Use of Pre-Application Report

APPLICATION NO: 19/60200/PREAPP

PREAPP DESCRIPTION: Erection of two bed single storey bungalow

LOCATION: Land Rear of Ashgrove, Maldon Road, Hatfield Peverel

1 ELEVATION A-A (FRONT ELEVATION - SOUTH)
SCALE: 1:100 @ A1

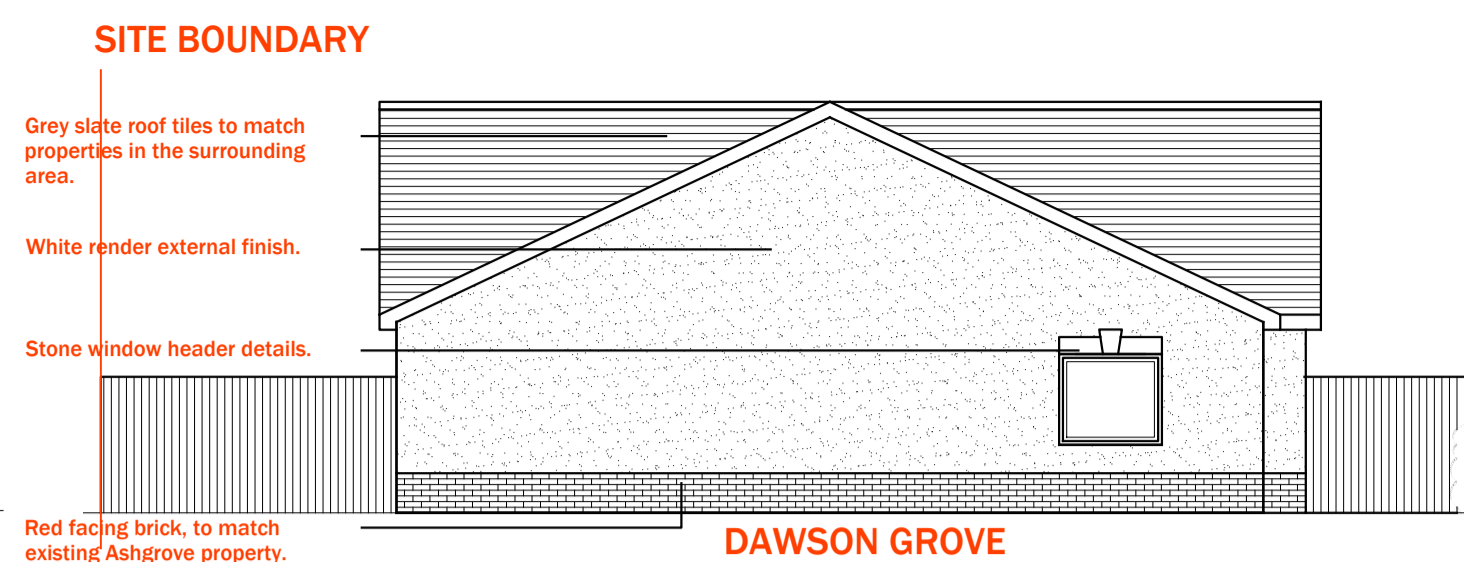
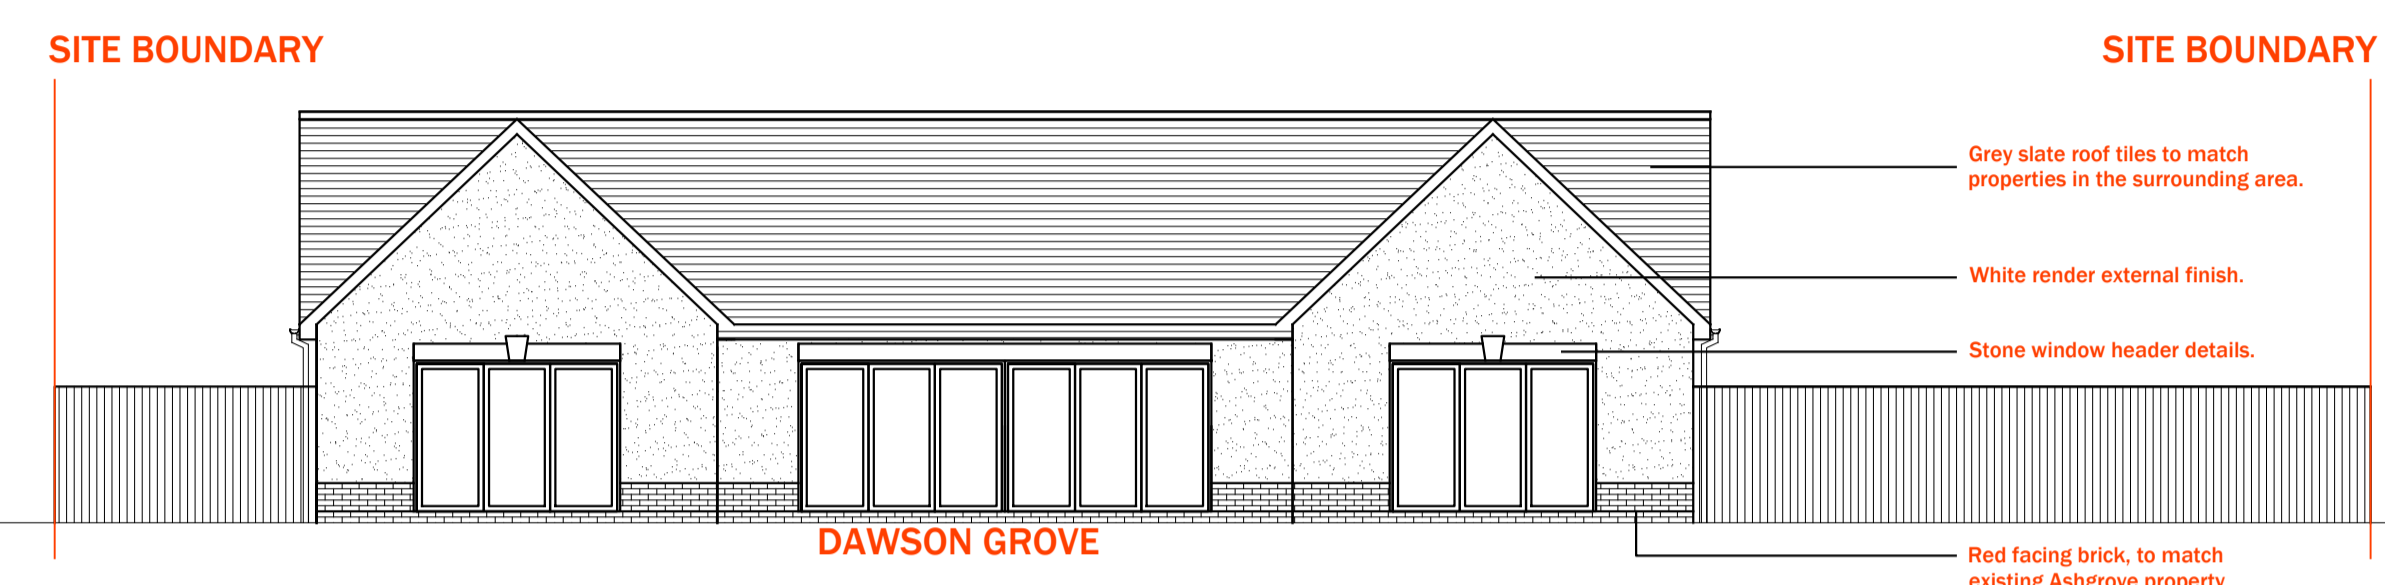
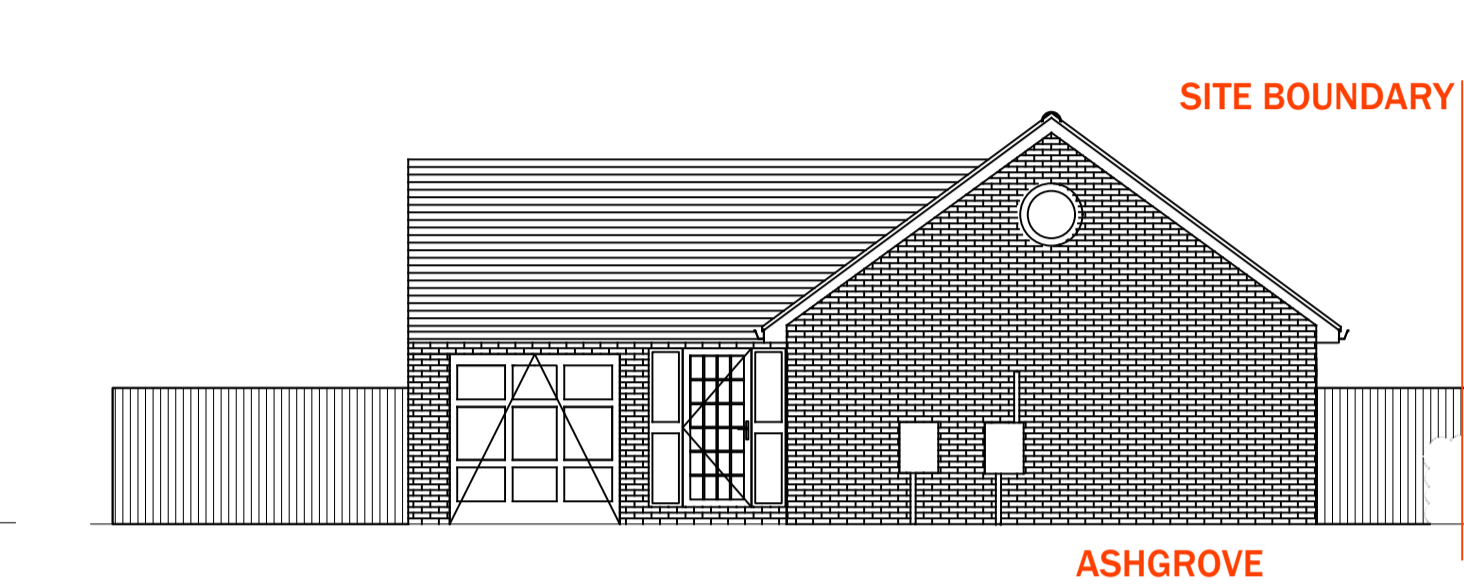
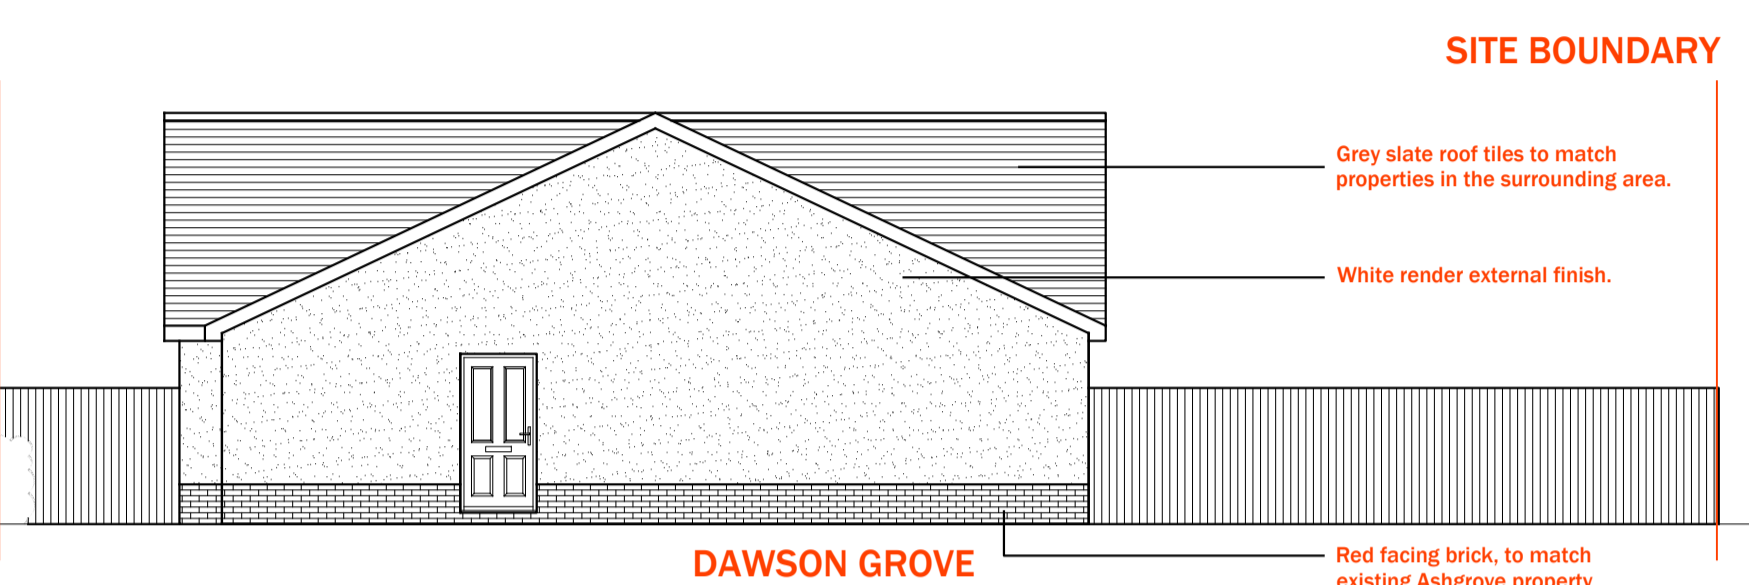
In terms of detailed design, whilst the dwelling in itself raises no objections, but there are concerns with the size, scale and massing which is significantly larger than the retained dwelling to which it relates. As discussed within the meeting, Officers would also not support accommodation within the roof space. The proposal would not therefore accord with the relevant policies.

The proposed new dwelling is surrounded by a combination of mainly detached houses, semi-detached houses, chalet Bungalows and bungalows (which have Velux windows installed into their roofs, which demonstrates that they have used their loft space for potential amenity space) To which I believe was an unjustifiable reason for concern in the pre app report, as other properties around the plot have used their loft space for amenity. There is a variety of property types that create the characteristics of the surrounding area. I do not believe the new proposed dwelling would be harmful to the characteristics of the area but bring value to the area. For example, the mix of roof tile colours surrounding the plot is between slate grey colour and brown. In which the proposal suggests matching the same colour grey slate as multiple properties surrounding. Along with a mixture of brick (to match existing red facing brick) of the existing property, and cream/white render. To match the existing surrounding area.

1 GROUND FLOOR PLAN
 SCALE: 1:50 @ A1

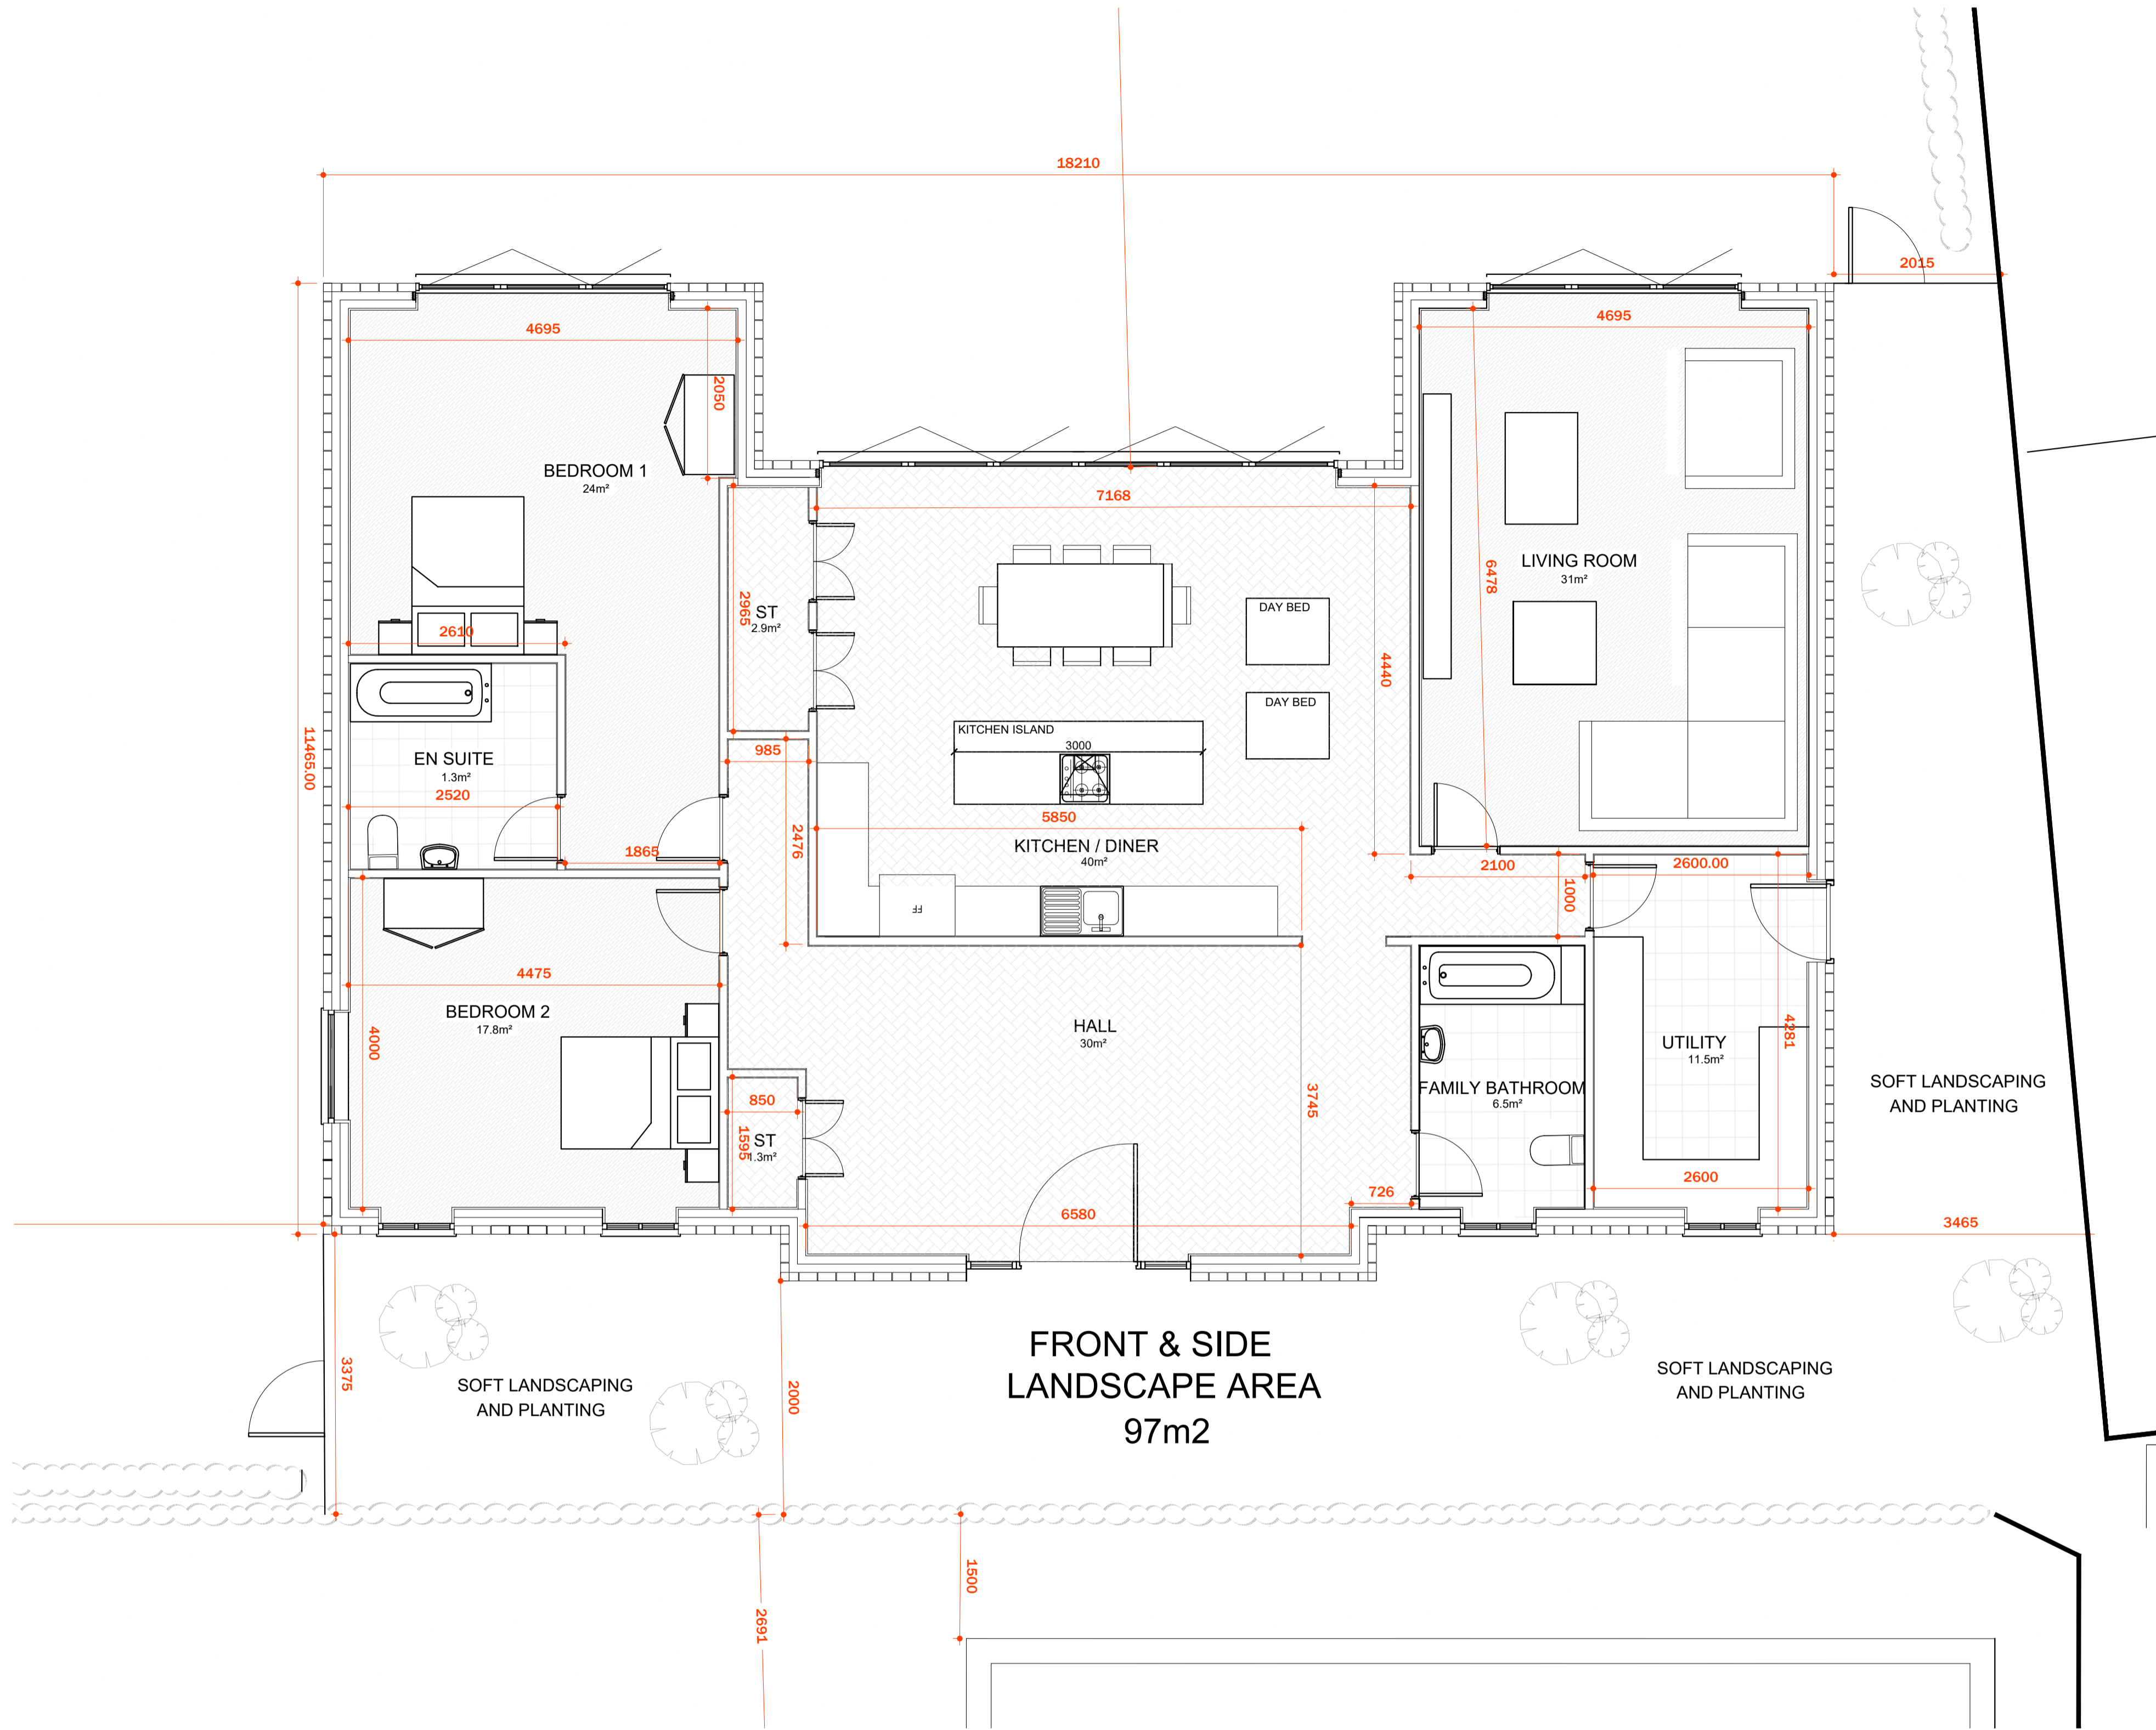
The floorplans indicate that bedroom 2 will have an outlook onto the shared boundary (understood to be a fence). Given the proximity of this, it would result in poor amenity in terms of light and outlook. Whilst this may be acceptable for a bathroom, utility room or secondary window etc., it would be unacceptable for a bedroom. (Also note the proposed flank utility room door would not be accessible). The proposal would therefore not accord with the relevant policies.

Since the pre application meeting in 2019 (19/60200/PREAPP) The floor plan has changed to suit the above comments. (Internal and external). The bedroom at the front of the bungalow now has a primary window overlooking onto the garden, leaving the smaller two windows facing the boundary of Ashgrove as secondary windows. The smaller windows facing the shared boundary are now secondary windows, as preferred in the pre app comments. The access to and from the new position of the utility, is to the north and suffices sufficient space to access from the flank wall. I have c amenity.

2 SITE PLAN
 SCALE: 1:500 @ A1

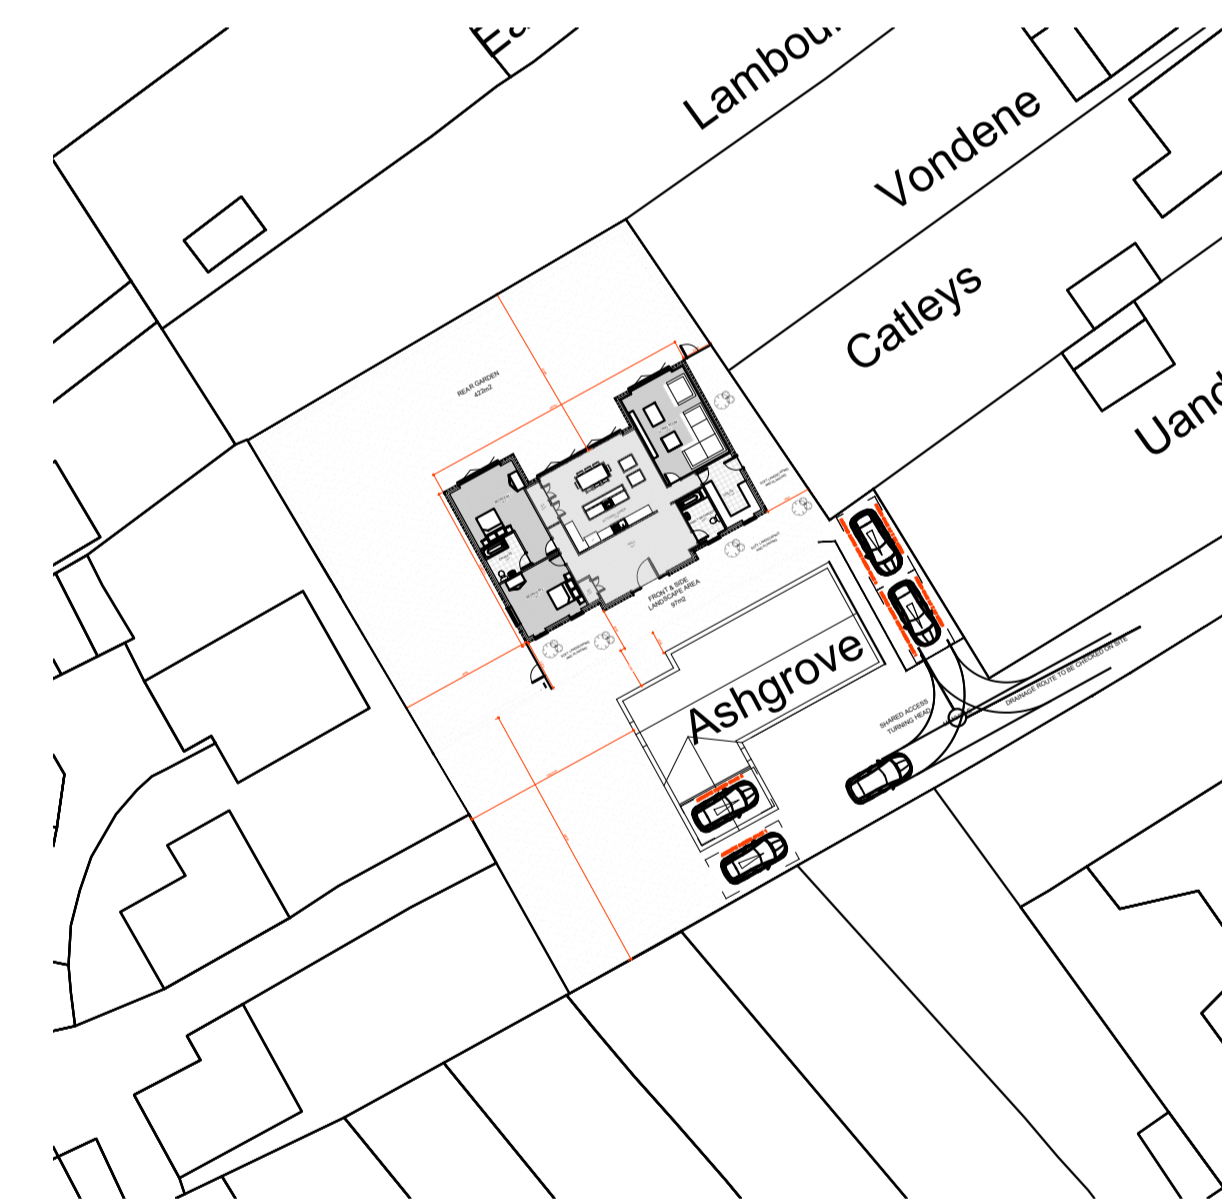
The plans do not detail car parking provision for the retained or proposed dwelling. You are advised that 2 parking spaces would be required for each dwelling.

However it does not appear that this would be of sufficient size to accommodate 2 spaces (parking space standards are 2.9 x 5.5 metres).

Officers would not wish to have hard surfacing harsh up to the existing dwelling. It is also unclear whether adequate turning and manoeuvring can be accommodated to ensure that all vehicles exit the site in forward gear.

Any application (or on-going preapplication discussions) should detail parking layout and turning for the existing and proposed dwelling. Please note that the highway impact of the proposal (including the acceptability of any proposed new access or intensification of the use of an existing access) is a matter for Essex County Council Highways and you may wish to undertake a pre-application submission with them with regard to highway matters.

The proposal demonstrates where two parking spaces are provided in tandem parking for the proposed Dawson Grove bungalow. Also, on the plan, it states where the current existing bungalow has efficient space for two parking spaces plus a garage. The plan indicated the turning head for cars to move and turn around with sufficient space down the private drive. This ensures that all vehicles can exit the site in forward gear.

Also, the proposed bungalow allows for soft surfacing and soft landscaping at the front of the property, and leading towards Ashgrove as demonstrated, and annotated in the plans.
